## Appeal Decision

**Appeal Ref: APP/R5510/D/25/3362076**

**40 Lawrence Drive, Ickenham UB10 8RW**

DRAWING TITLE: PROPOSED DRAWINGS

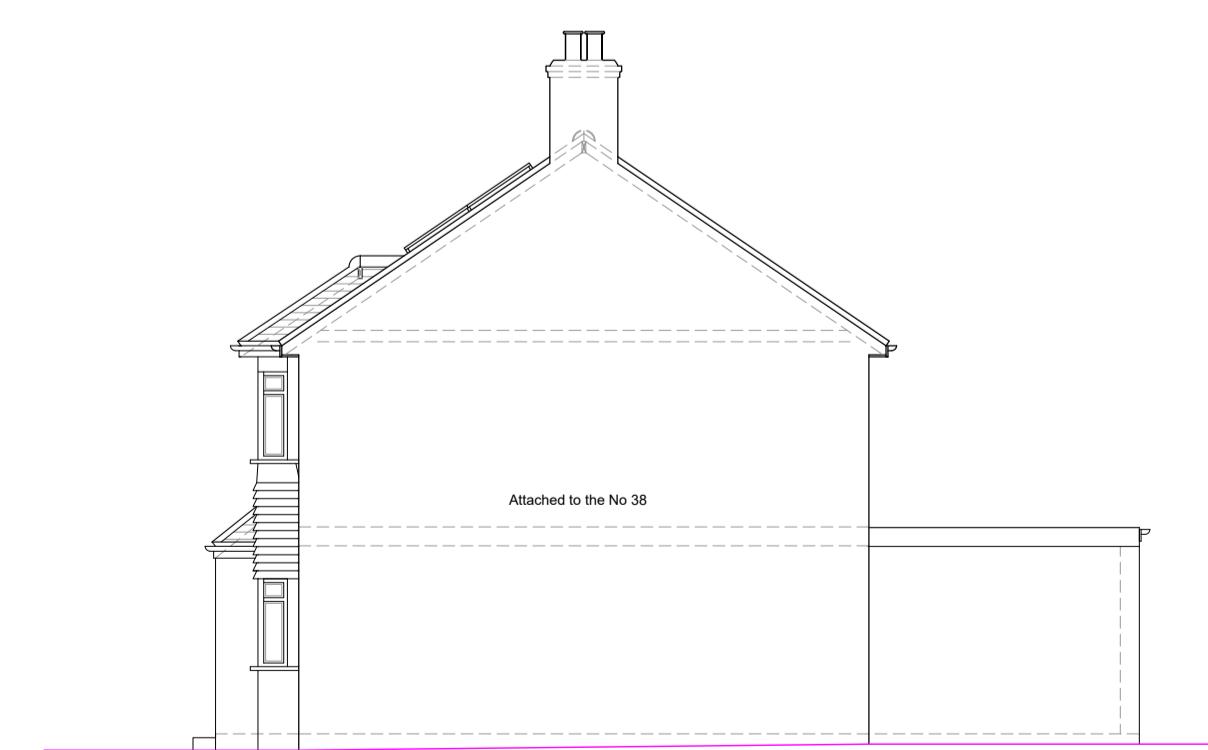
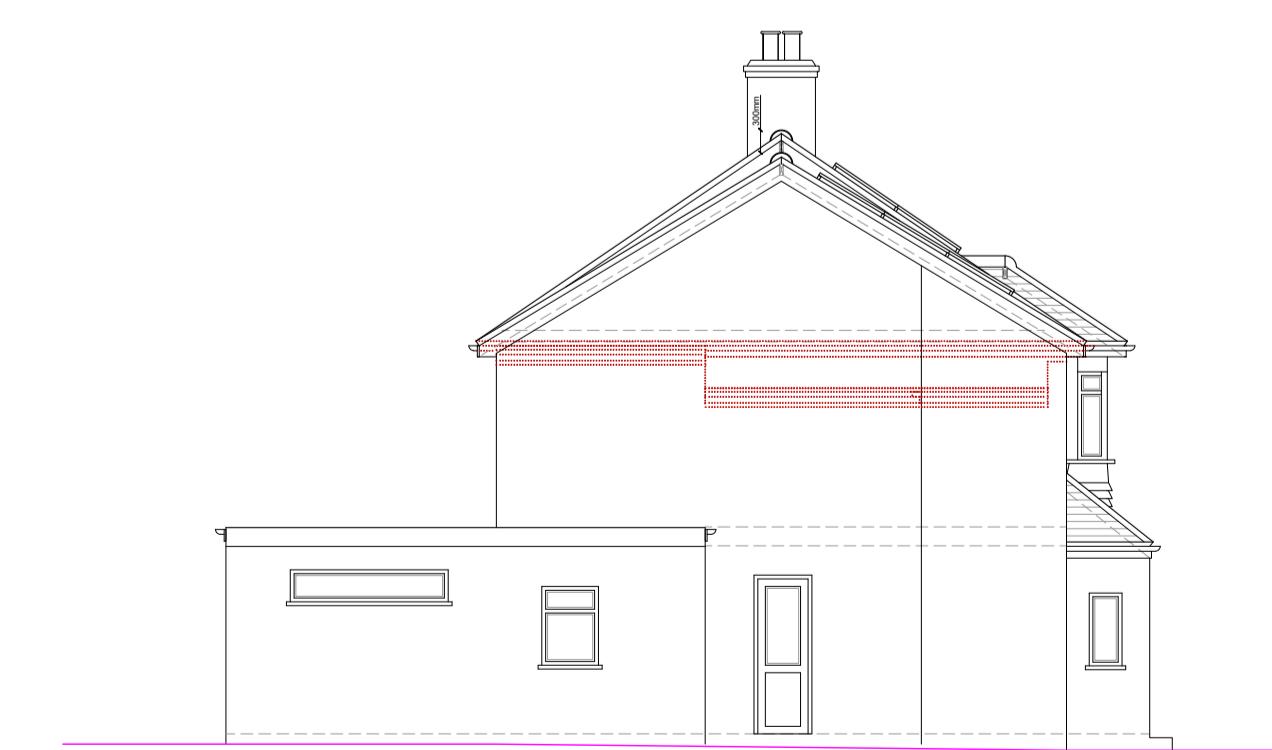
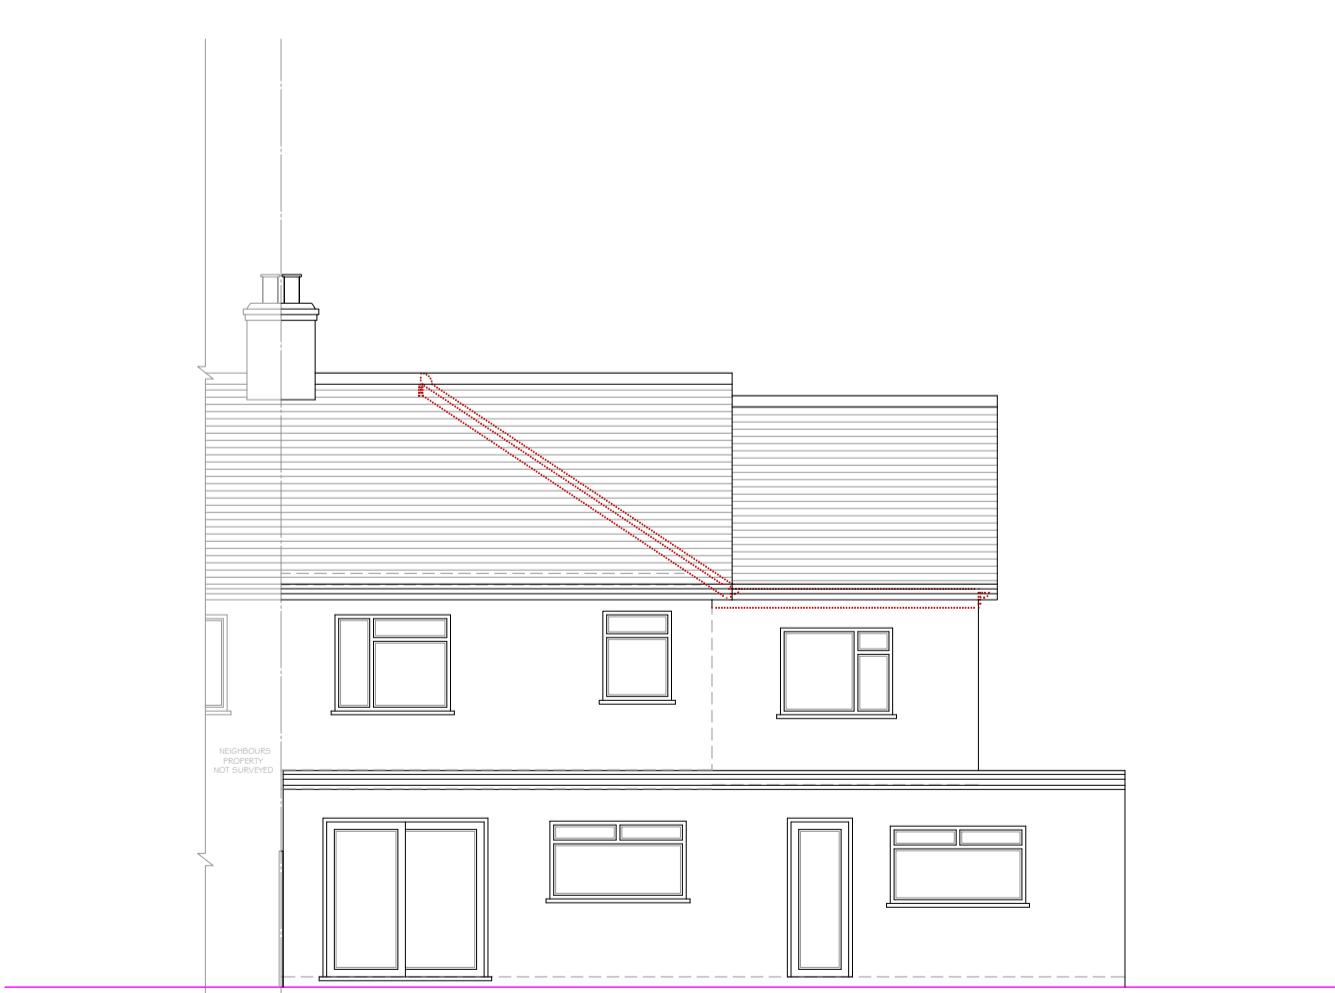
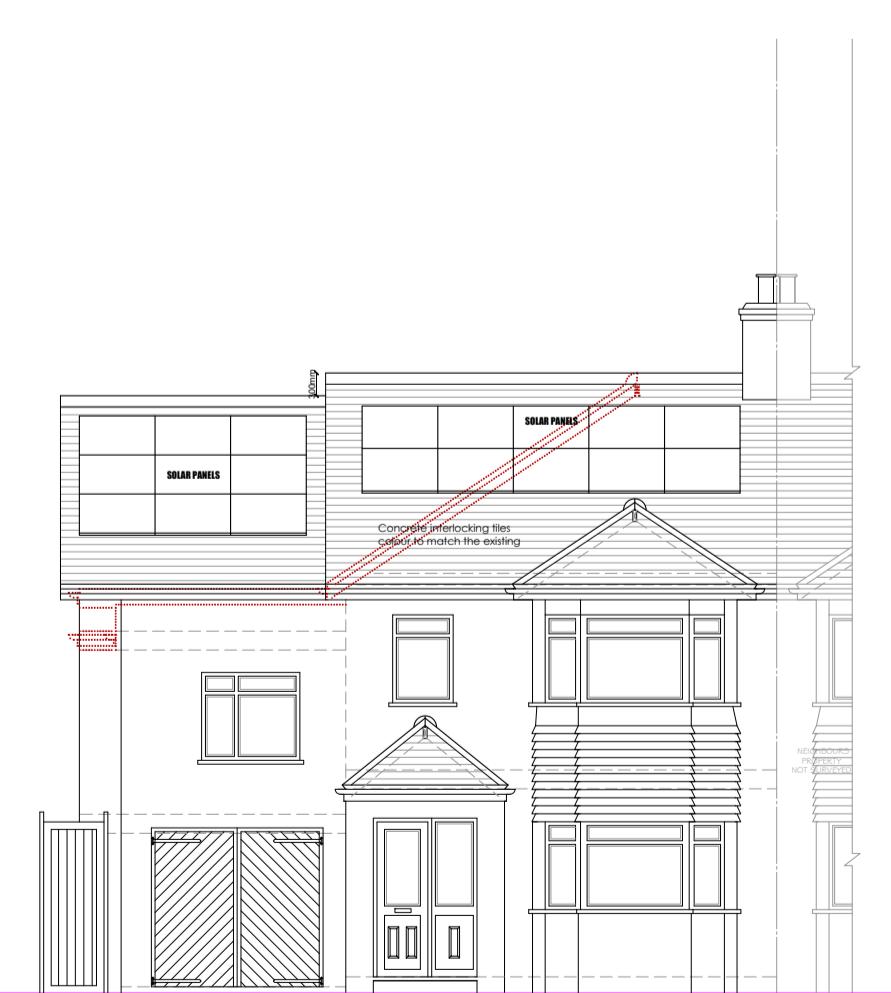
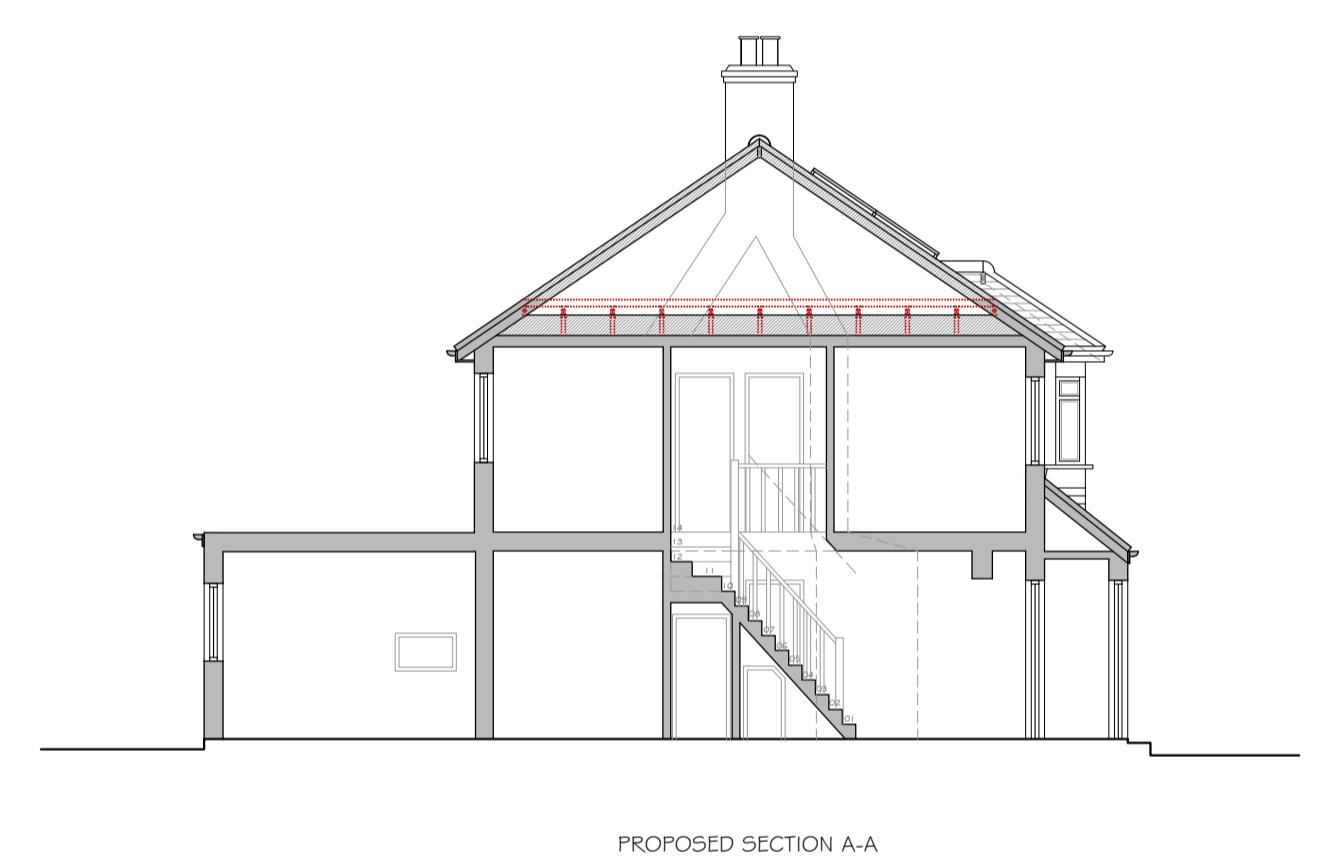
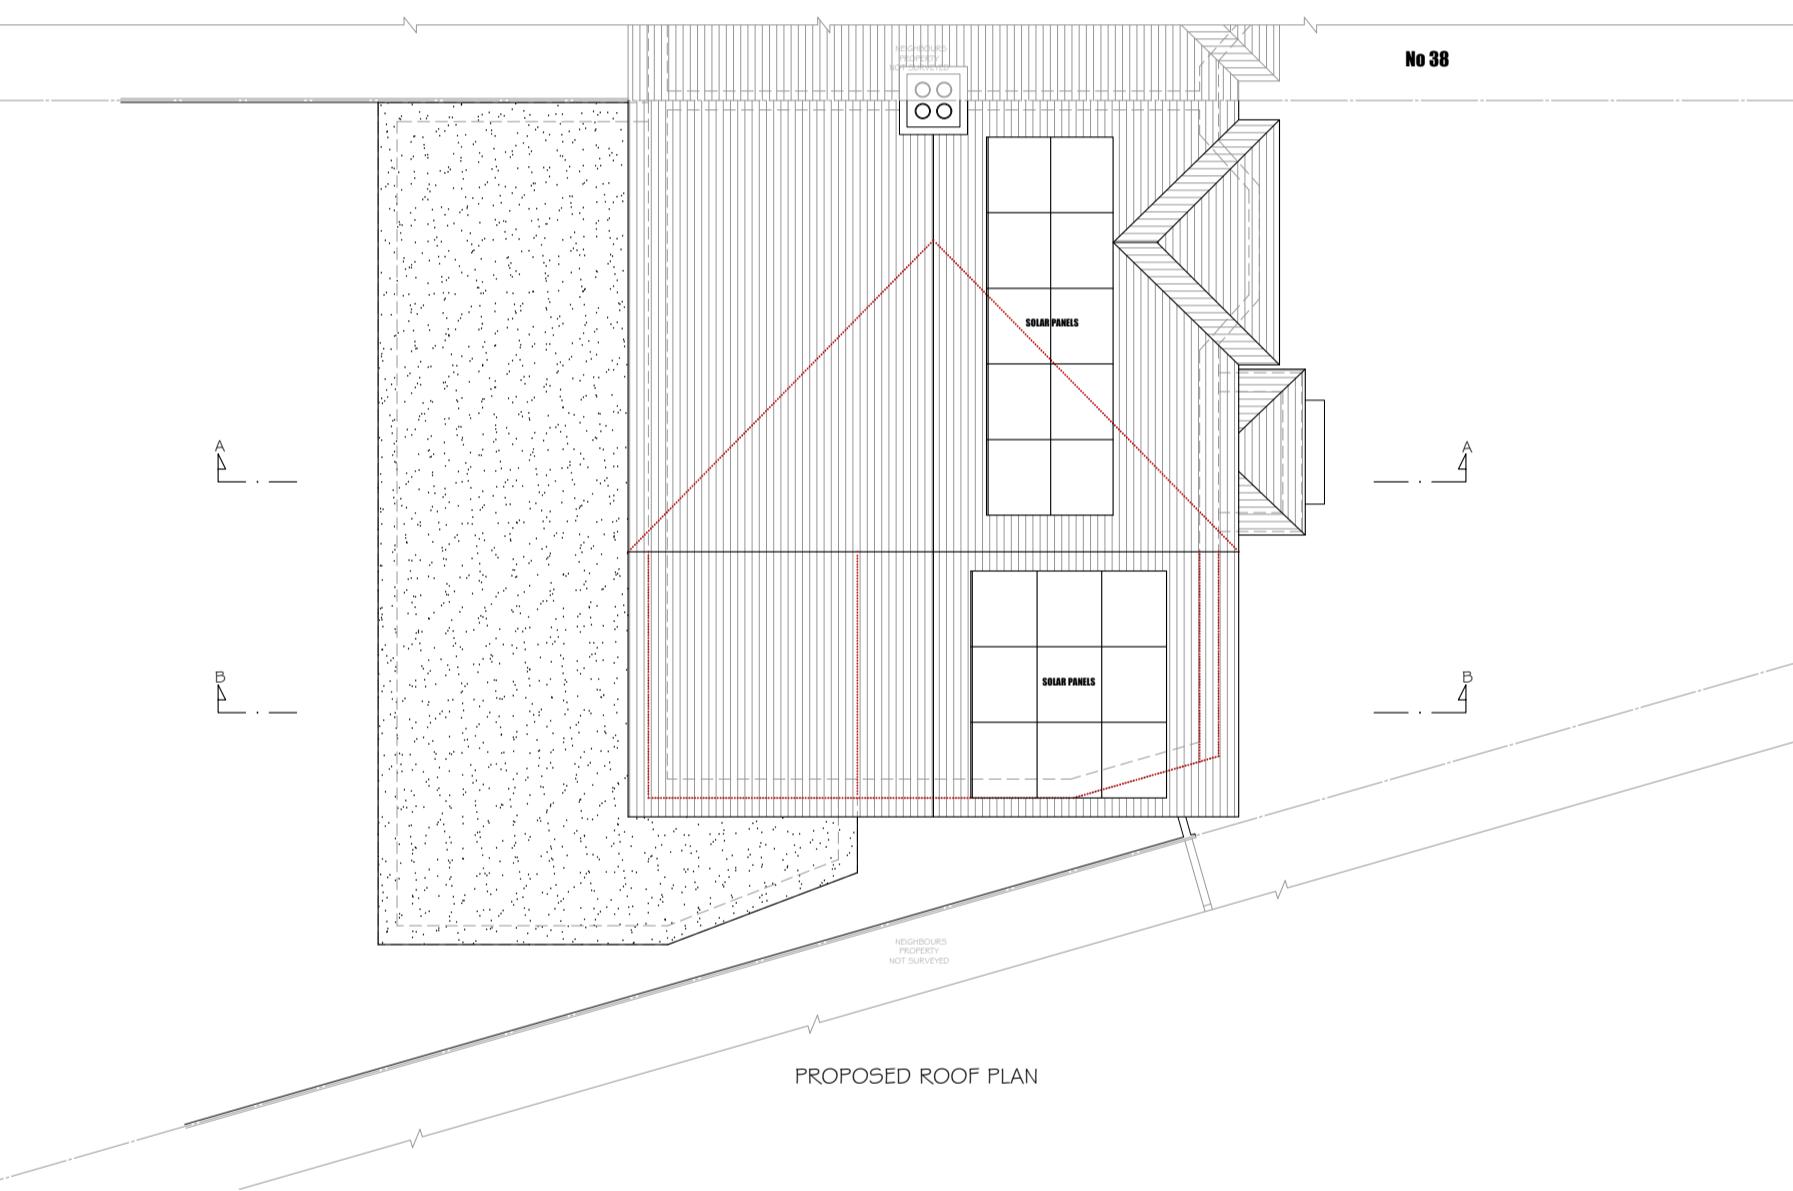
5. Regrettably, my assessment is that the appeal scheme would look very ill-at-ease on this individual property, on this pairing, and in this streetscene generally. The development would be too strident, the works would be excessive in scale and lack suitable subservience, and gable ends would dominate in a position where this would be inappropriate. The very slightly lower ridge of the new side roof does not display subservience in my opinion. Overall, I am concerned that the size and design of the roof extensions,

compounded by the planned roof panels, would be overly impactful and excessive, harmful to the qualities of the existing dwelling, its semi-detached symmetry, and the character and appearance of the street. Any roof proposals would need to be of a markedly more subtle nature and the panels reduced to achieve aesthetically suitable development in my opinion. Total symmetry is not always called for but this scheme would go too far out of line.

7. I do understand the wish to undertake modernisation and the matter of encouragement for, and necessary orientation of, solar panels. I note the 'permitted development' fall-back case put for the latter but, in this instance, they are proposed as part of a new roof form. I considered the roof alterations drawn to my attention and found variation in size, form and positioning. I do not know the planning background of the examples but certainly a number would not be a suitable benchmark of good design. In any event I must determine the submitted scheme on its own merits. I have carefully considered all the points raised by the Appellant but these matters do not outweigh the concerns which I have in relation to the main issue identified above.
